PEARTREE HILL SOLAR FARM DEVELOPMENT CONSENT ORDER (“THE PROPOSED ORDER”)

**ALBANWISE LIMITED (“AL”); ALBANWISE SYNERGY LIMITED (“ASL”); ALBANWISE FARMING LIMITED (“AFL”); AND FIELD HOUSE RENEWABLES LIMITED (“FHRL”)
(INTERESTED PARTY REF.: F04E592CD) (together “ALBANWISE”)**

**POST HEARING SUBMISSION
SUMMARY OF ORAL SUBMISSIONS
MADE AT CAH2**

Streets, Rights of Way and Access Plans

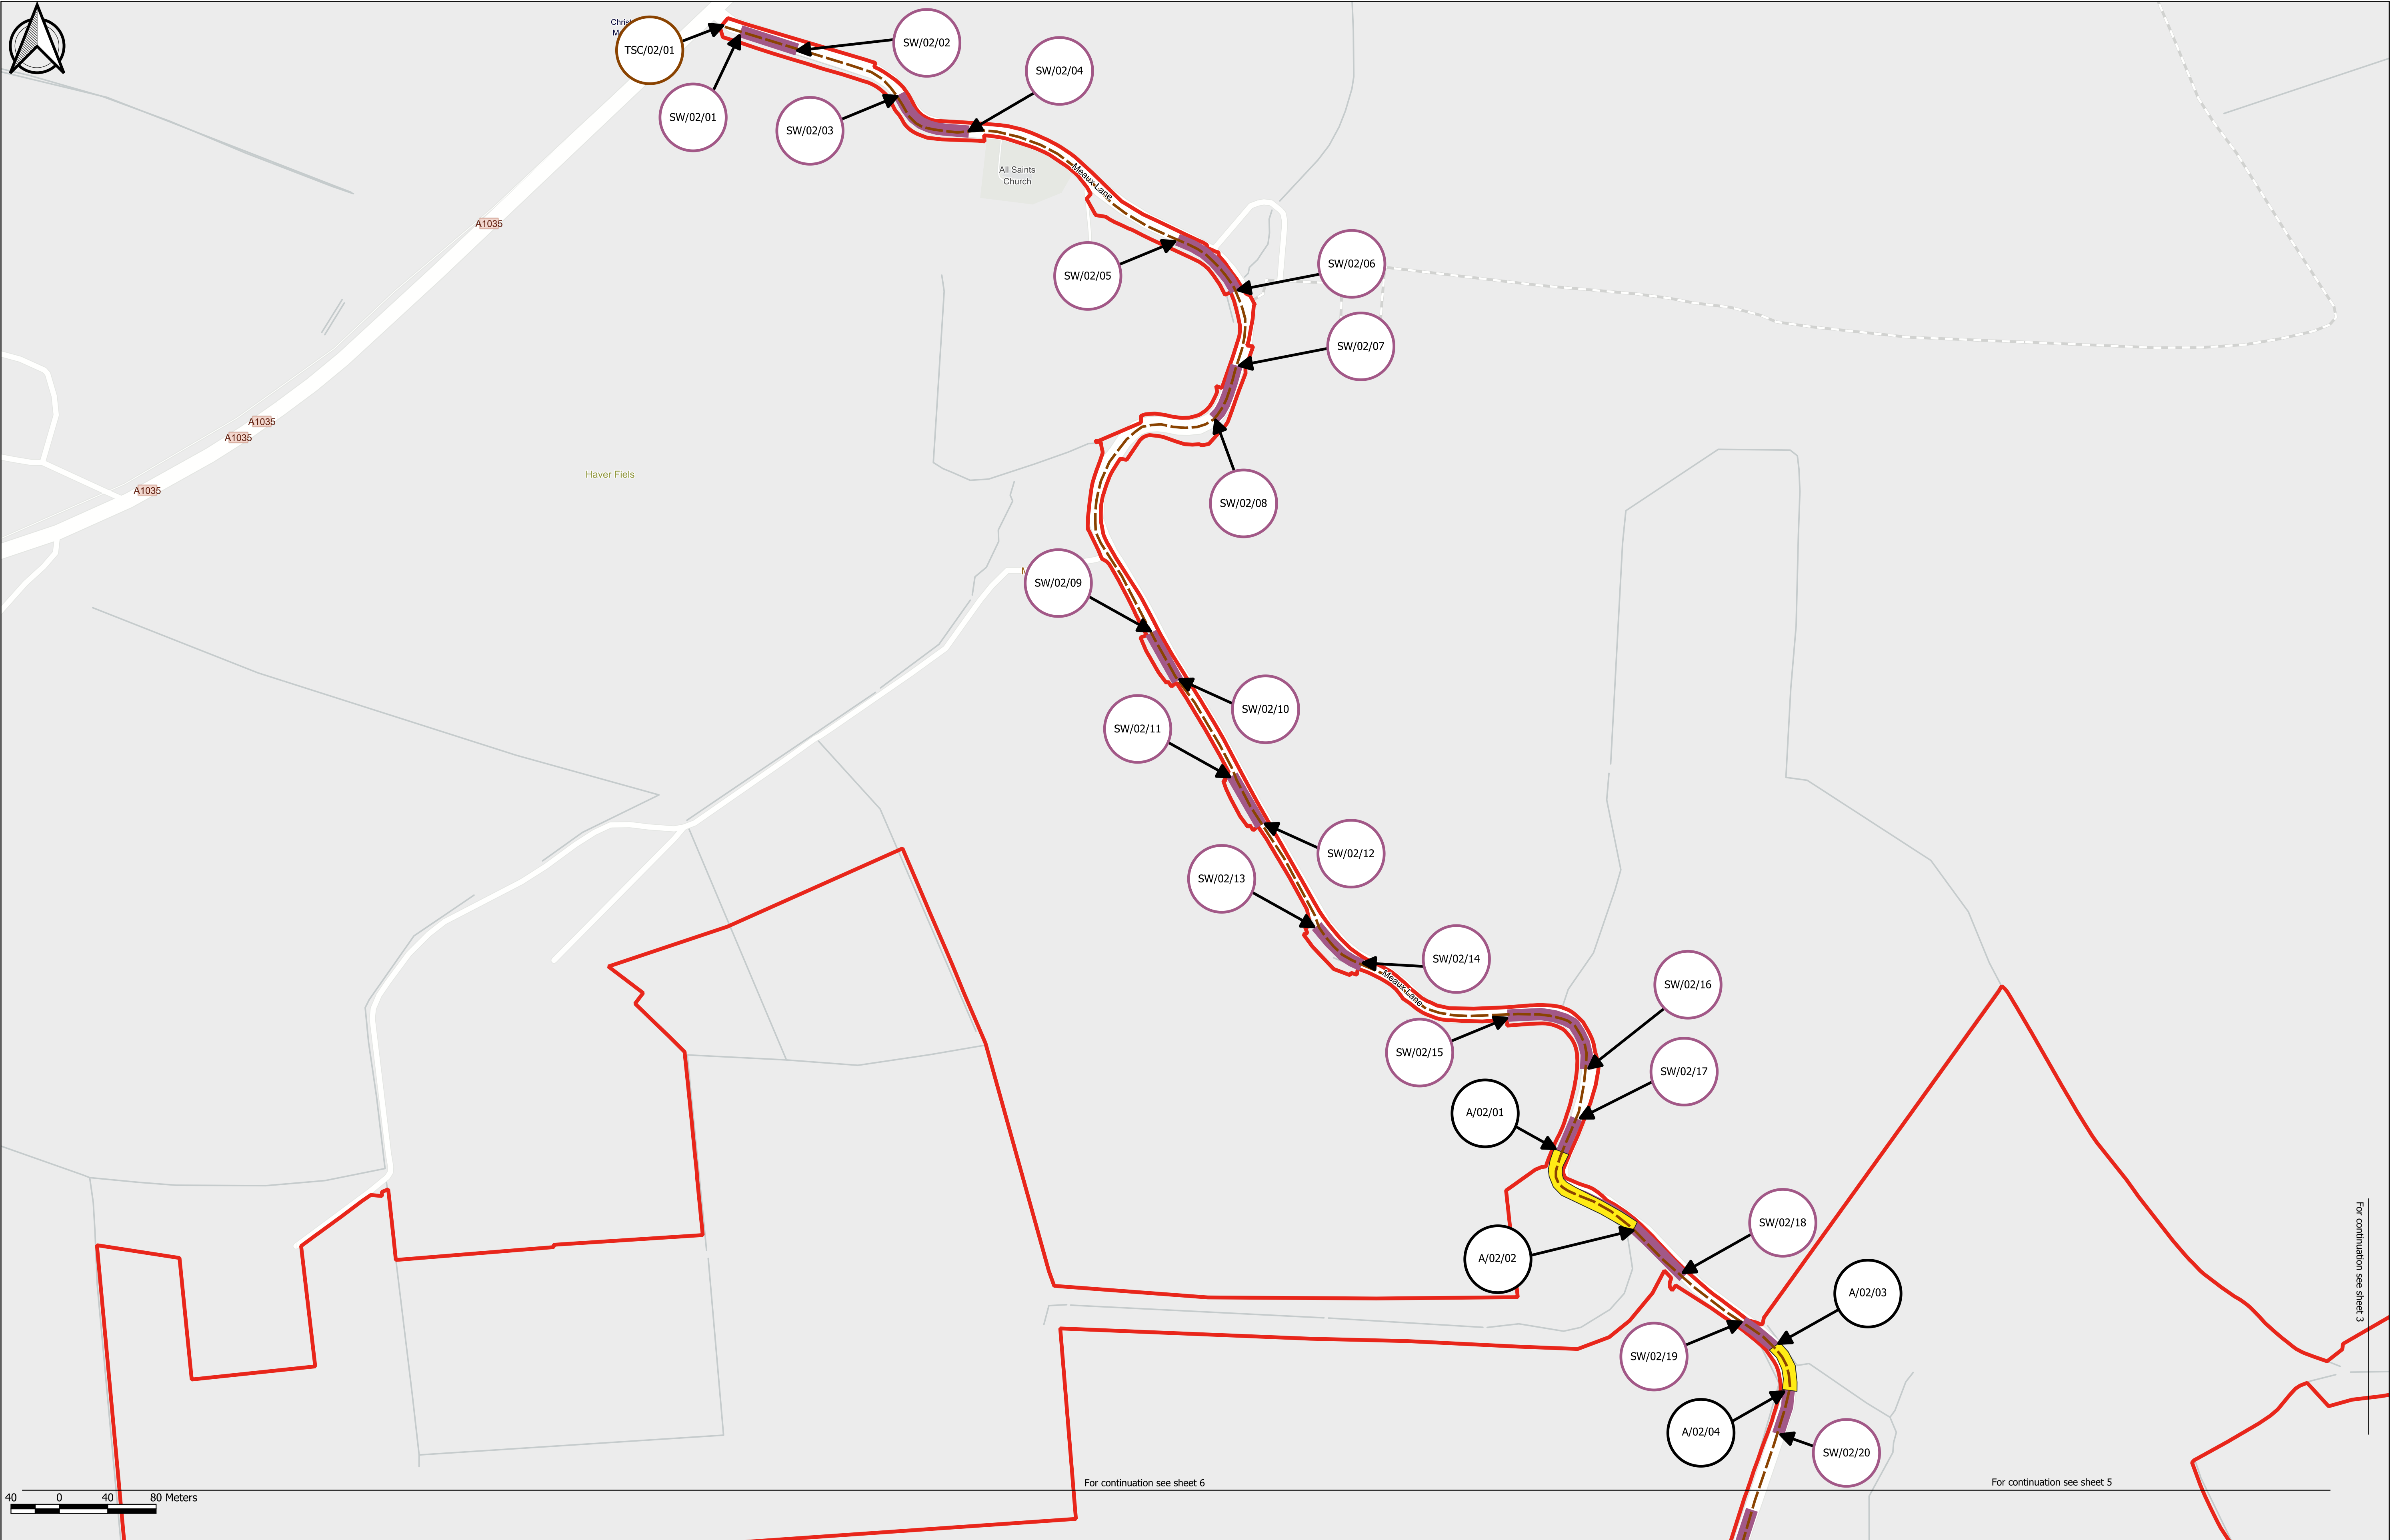
- (iii) Thirdly, the Applicant relies on the reduced need for hedgerow and vegetation clearance between the points marked A/02/01 and A-02/02 on Sheet 2 of the Streets, Rights of Way and Access Plans [**PDA-005**]. What is required at that location is the provision of an access track of 4-5m in width. As such the requirement for removal is small and can be no more than say 20m. Again, no assessment has been made of the requisite hedgerow removal from the proposed new access track and so comparative analysis has been avoided. [**RR-054, App.4, Alternative Access Plan**] shows within Plot 2A-4 at the southern edge of the proposed FHSF immediately after the access track turns through 90 degrees to the south east a hedgerow of about 40m which will need to be removed. Albeit, this hedge is not identified for removal in [**REP4-004**] but designs supplied to Albanwise by the Applicant show an overlap with the proposed passing bay and it is clear that at least some of it will require removal. Even on the Applicant’s partial analysis, the removal of a limited amount of hedgerow cannot possibly amount to a compelling case in the public interest. When a proper analysis is carried out, however, it shows that more hedgerow is lost in the Change Application, not less;
